MECKLENBURG COUNTY
Land Use & Environmental Services Agency

MEMORANDUM

To: Charlotte-Mecklenburg Planning Commission
From: LUESA, Mecklenburg County
Date: 5.27.21
Subject: Rezoning Petition Comments

2021-063: Shopton/Beam Industrial

SITE PLAN

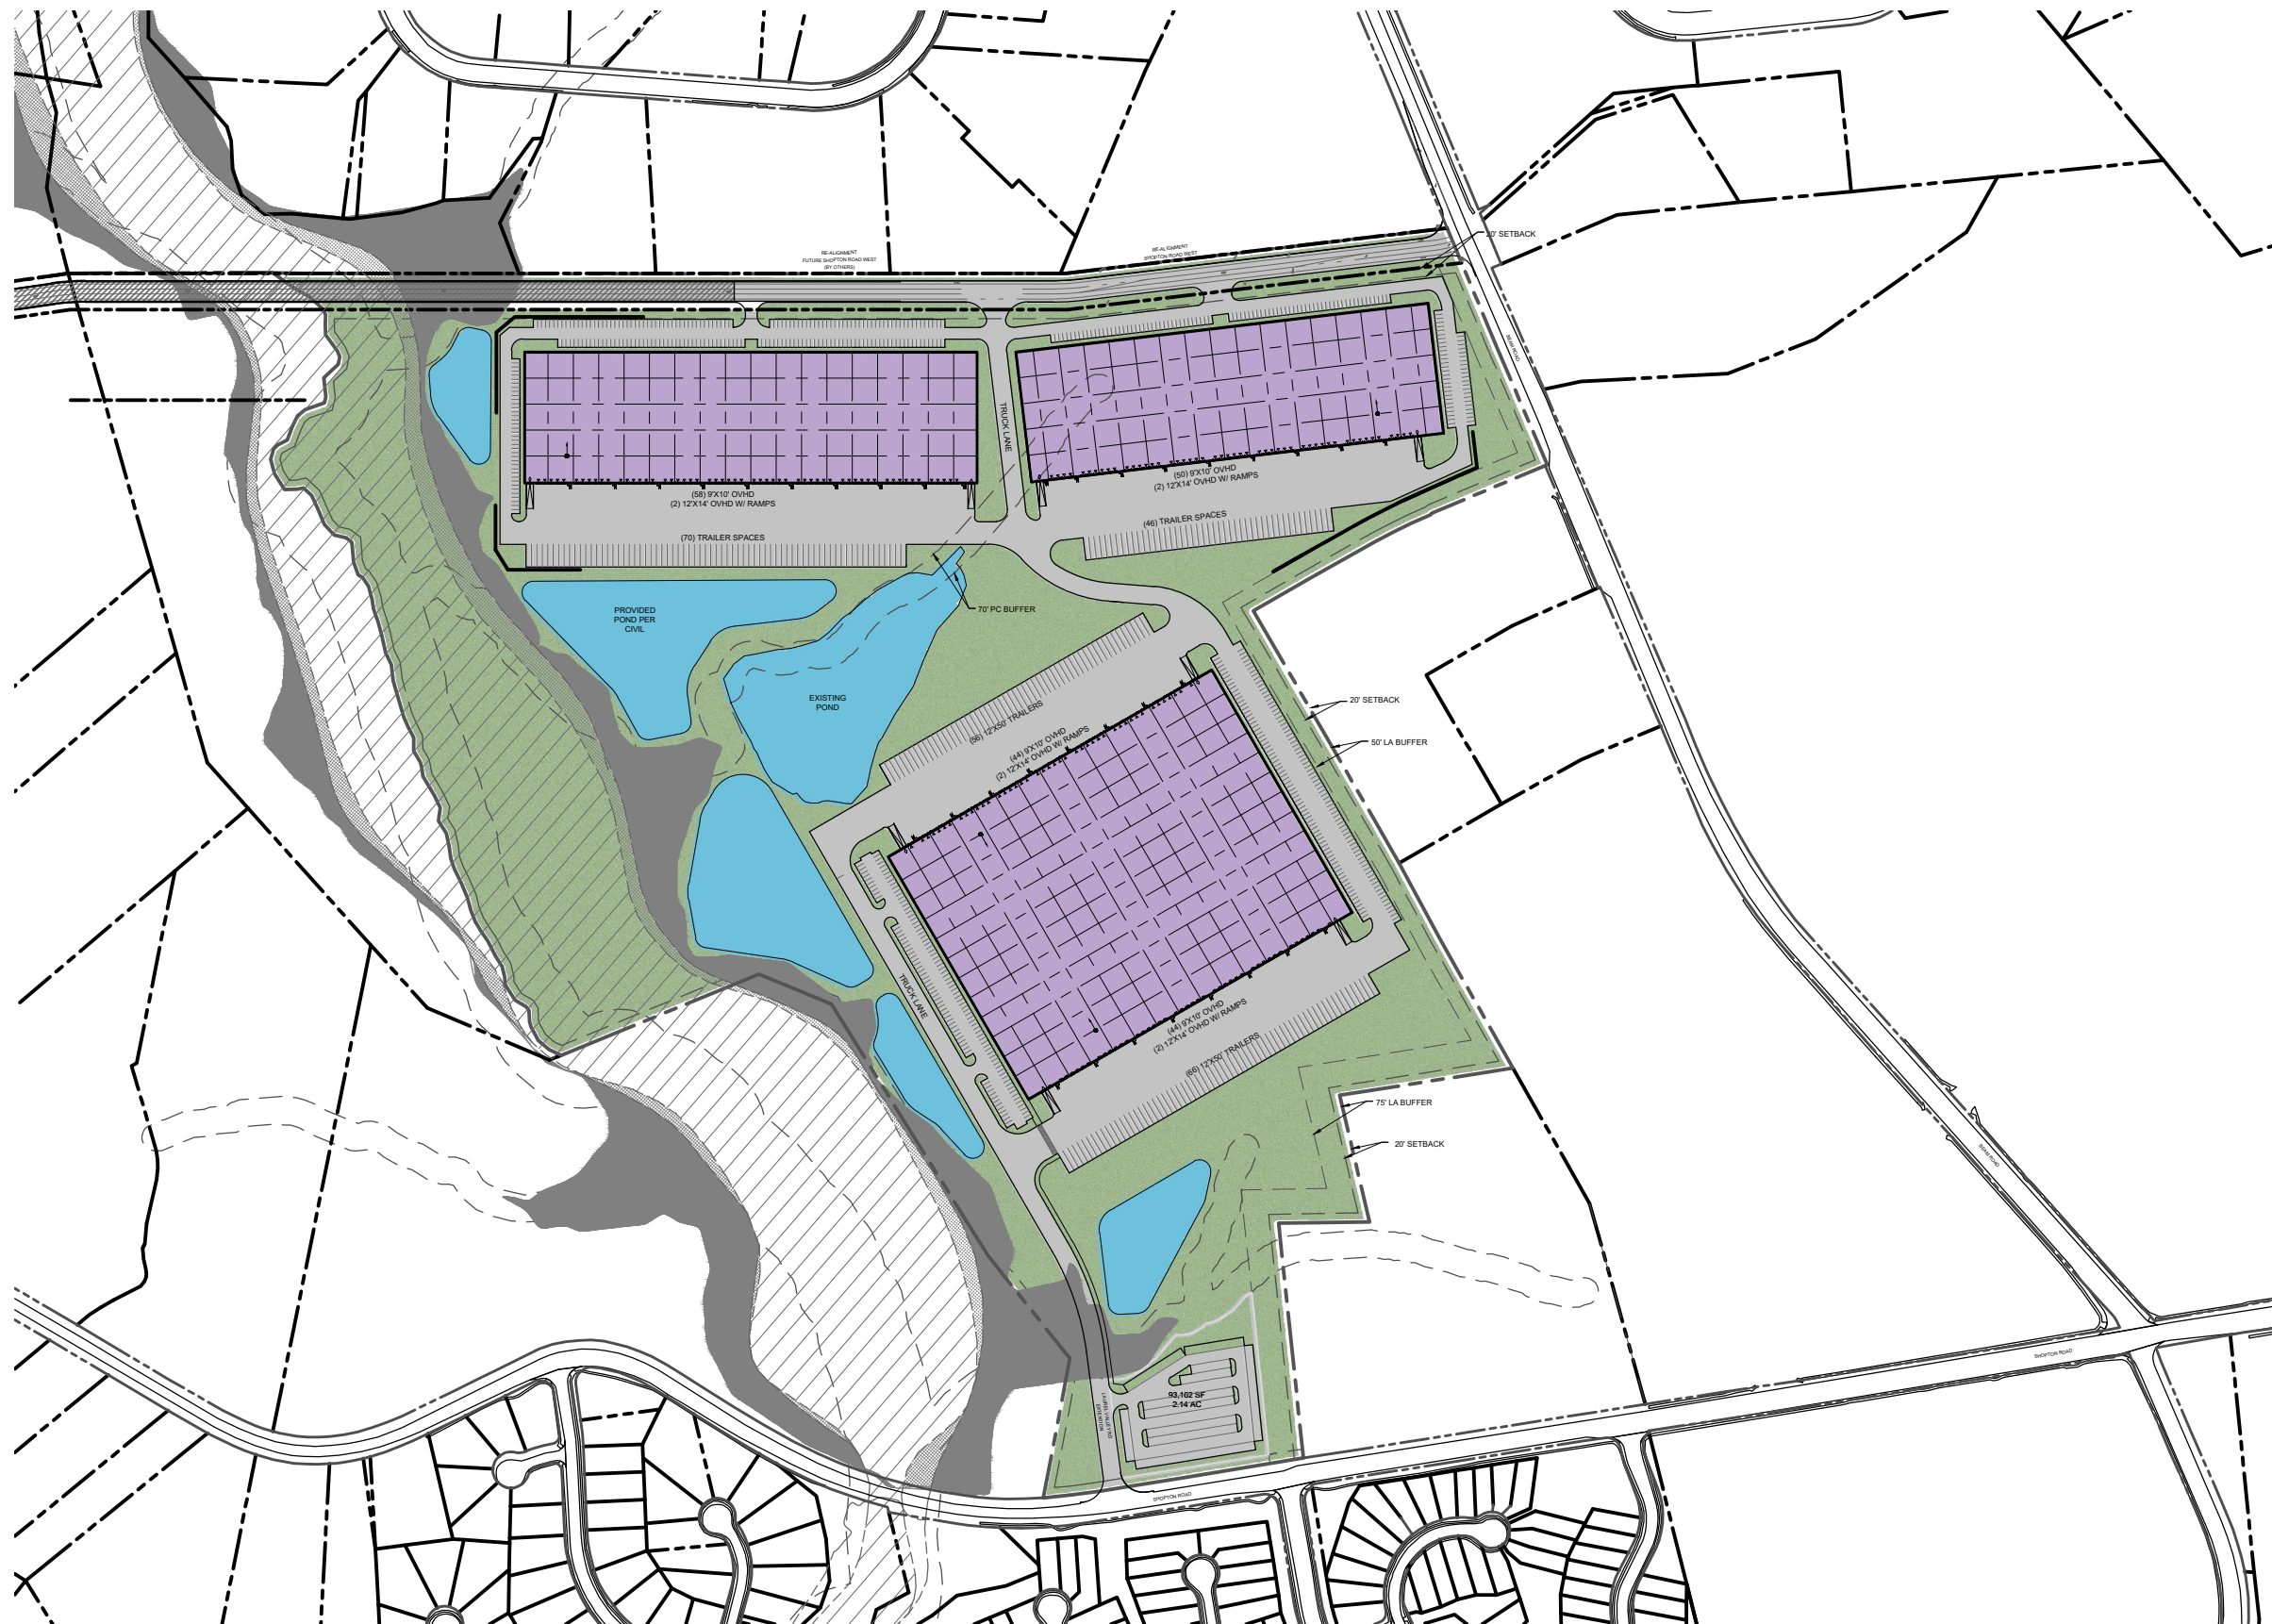
Storm Water Services Comments: A Floodplain Development permit must be obtained documenting compliance with the City of Charlotte Floodplain Regulations for all development occurring in the floodplain. In addition, staff recommend any structures proposed within the Community Special Flood Hazard Area be constructed to a Flood Protection Elevation equal to the Community Base Flood Elevation plus two (2) feet of freeboard based upon recent analyses of the future floodplains supported by the Storm Water Advisory Committee.
